SUBMISSION FOR APPLICATION No. SSD5752

Please find the submission below that OBJECTS to the current Development Application SSD5752.

We are owners in the Goldsbrough, a residential building of approximately 500 apartments, which is located directly behind the proposed ICC Convention centre.

ICC CONVENTION

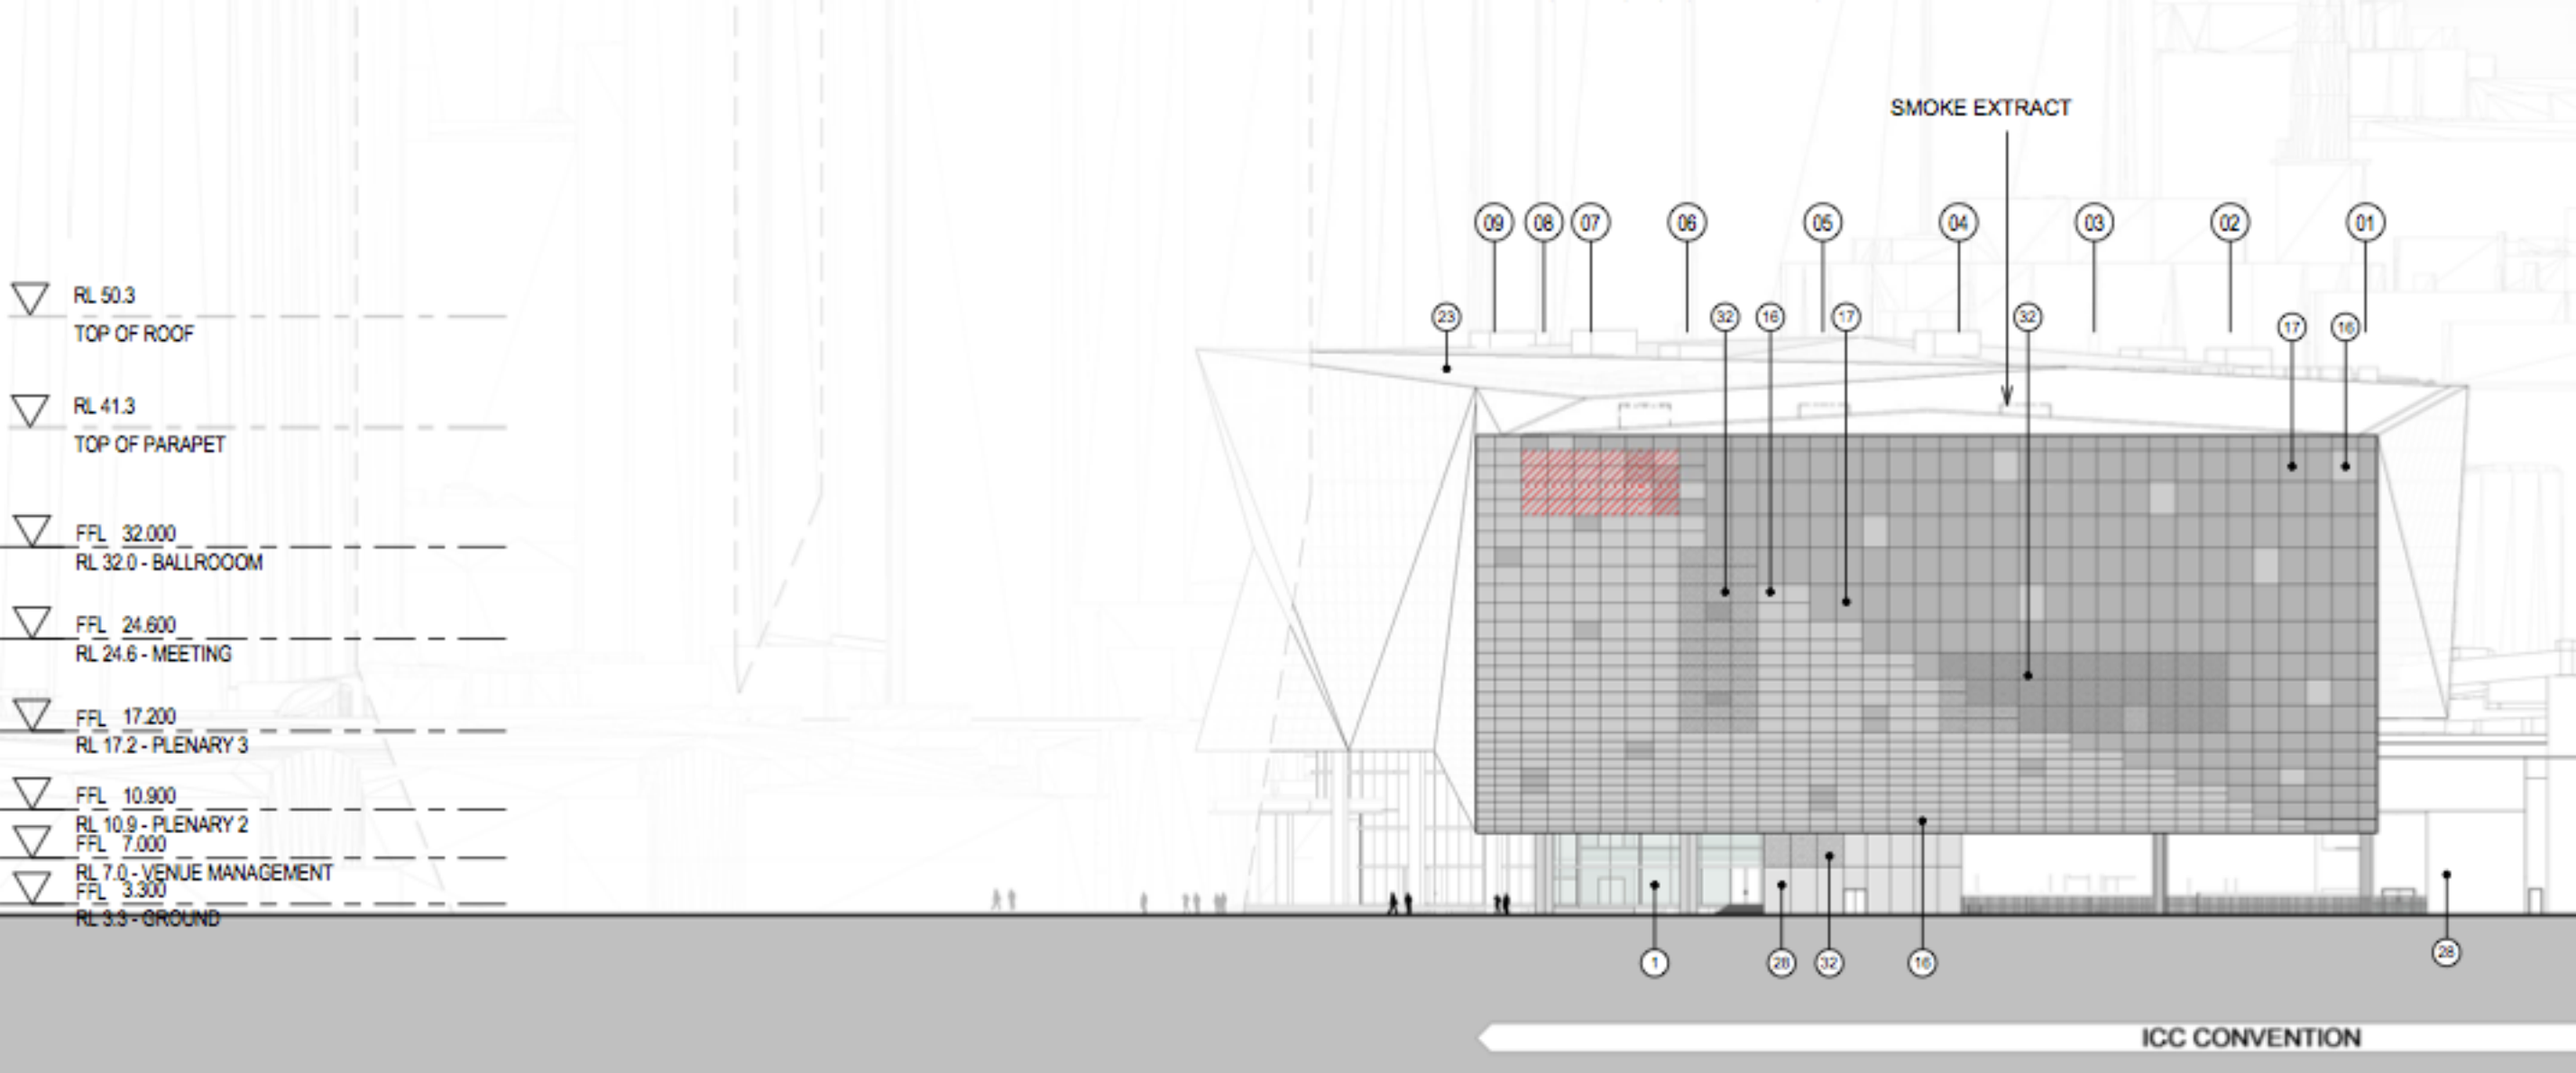
We firstly object to the height of the proposed new ICC convention centre which is nearly to the top of the Goldsbrough's current height.

In the DA plans the proposed height is RL 50.3 which will block the entire view to Darling Harbour and the city from the Goldsbrough's eastern facing apartments. There is supposed to be a concept of view sharing in the city but in this case the whole of the eastern view of the Goldsbrough will be blocked out by the new ICC convention centre.

In place of the current city skyline and Darling Harbour view there will be a flat blank metallic wall in its place, which is the rear of the proposed ICC convention building. The front of the ICC building looks to be nicely designed with glass and is broken up in angles, but the Goldsbrough will be facing an ugly flat back wall made of aluminum and mainly Grey.

Please see the diagram of the back of the ICC convention centre below , which will be approximately the same height as the Goldsbrough.

DRAWING TITLE
 GA PLANS - LOBBY - LEVEL 0 (RL 3.3)

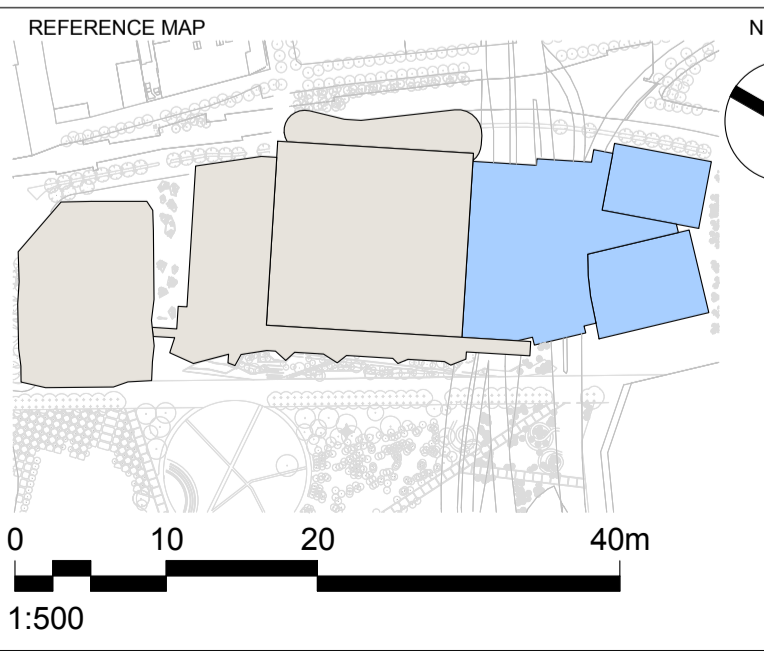
The proposed changes at Darling Harbour seem to take away an extremely important thoroughfare for the residents and guests of the Goldsbrough. From the plans it looks like the current overhead pedestrian walkway next to the Convention monorail station is being removed. Currently it is the easiest and safest walkway to enter the Darling Harbour precinct from the Western side.

The alternative link from the Western Distributor is not a convenient alternative to what is currently there. How are pedestrians especially with children meant to cross to and from Darling Harbour in a safe way at all hours ?

From the Architectural drawings below it shows how the current walkway is removed in the proposed plan

This is the walkway being removed
